**Application 3/2024/0726**

**Location: Shackleton's Garden Centre Ltd, Clitheroe Road, Chatburn, BB7 4JY**

**Proposal: Proposed two-storey extension to rear and re-modelling of home and garden centre, including additional indoor and outdoor retail space and increased cafe area and play area**

I refer to the letter from the United Utilities (UU) dated 6<sup>th</sup> November 2024 in which UU stated that they were unable to recommend the discharge of Condition 11 & 17 relating to surface water drainage. UU gave the following reason (in italics below) and our comments are included below each reason given.

Project No:	Drawing No:	Issue:
10301	101	P6

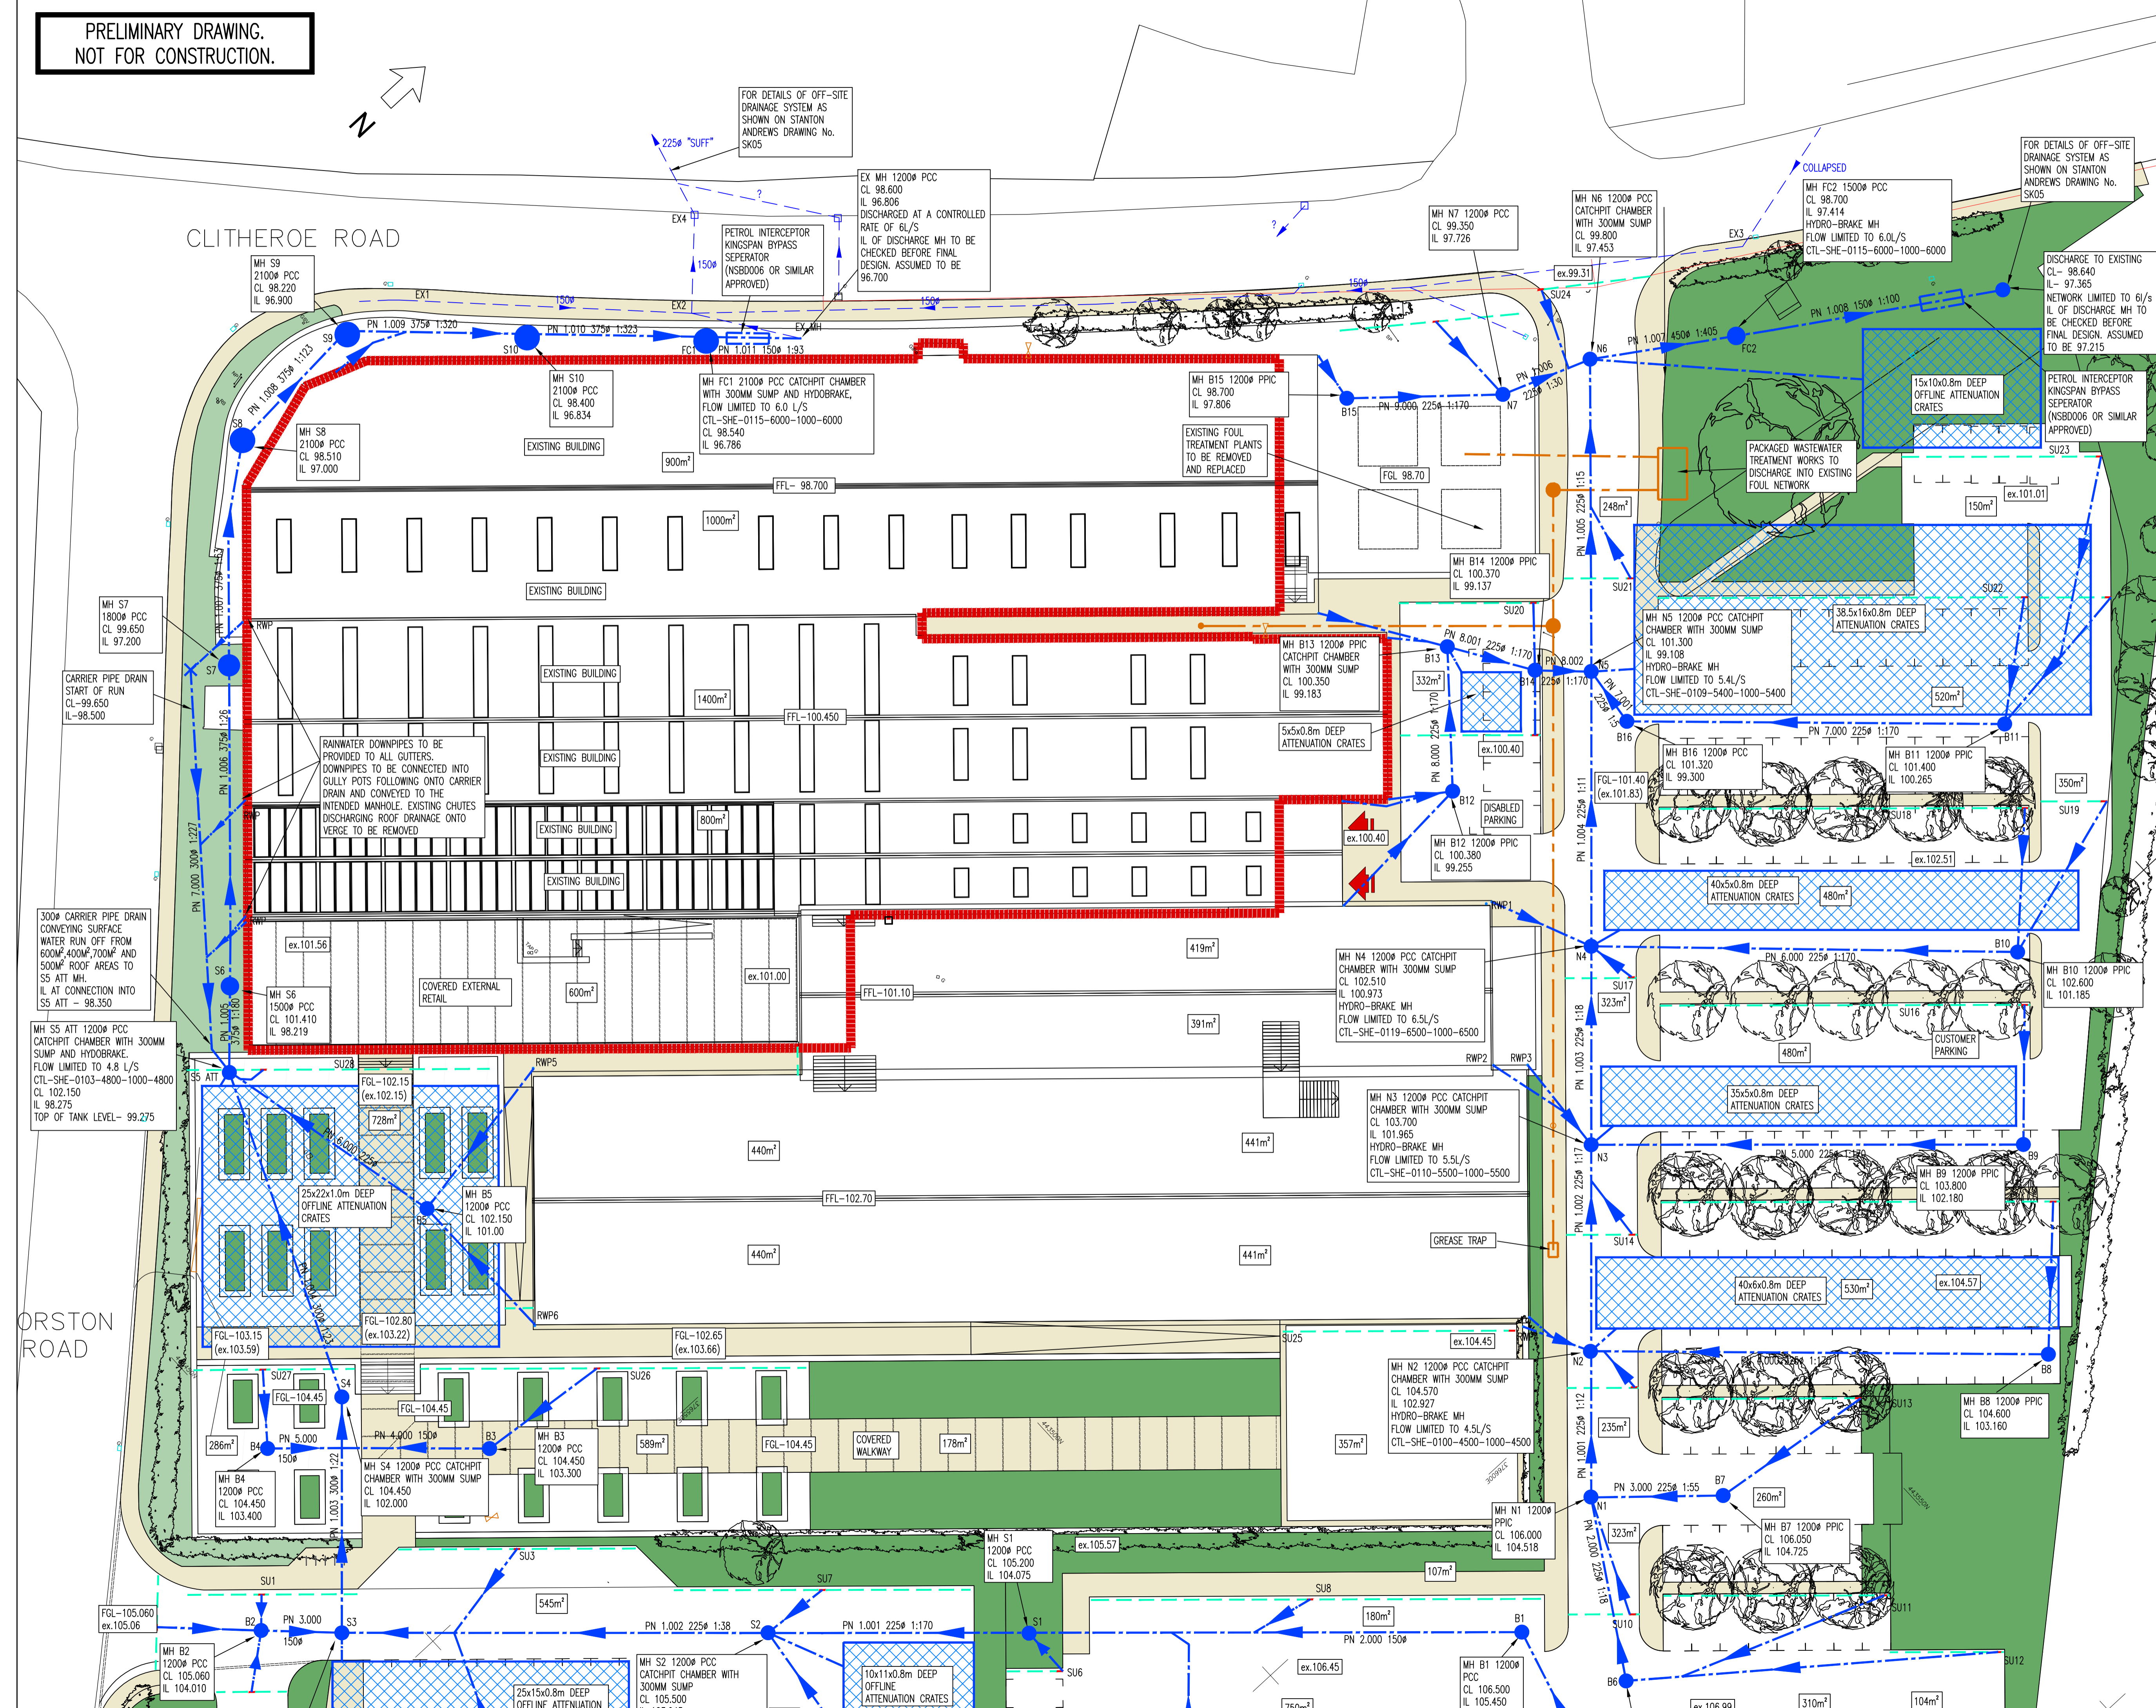
- 1. The drainage drawings do not show where the foul outfall ultimately discharges.*

Drawings 10301/101/P7 and 10301/102/P4 have been updated to show that the treated effluent will be discharged into the SW drainage network. In the same manner as the existing arrangement. The existing treatment plant will be replaced with a larger unit capable of treating increased flows from the proposed new toilets and kitchen.
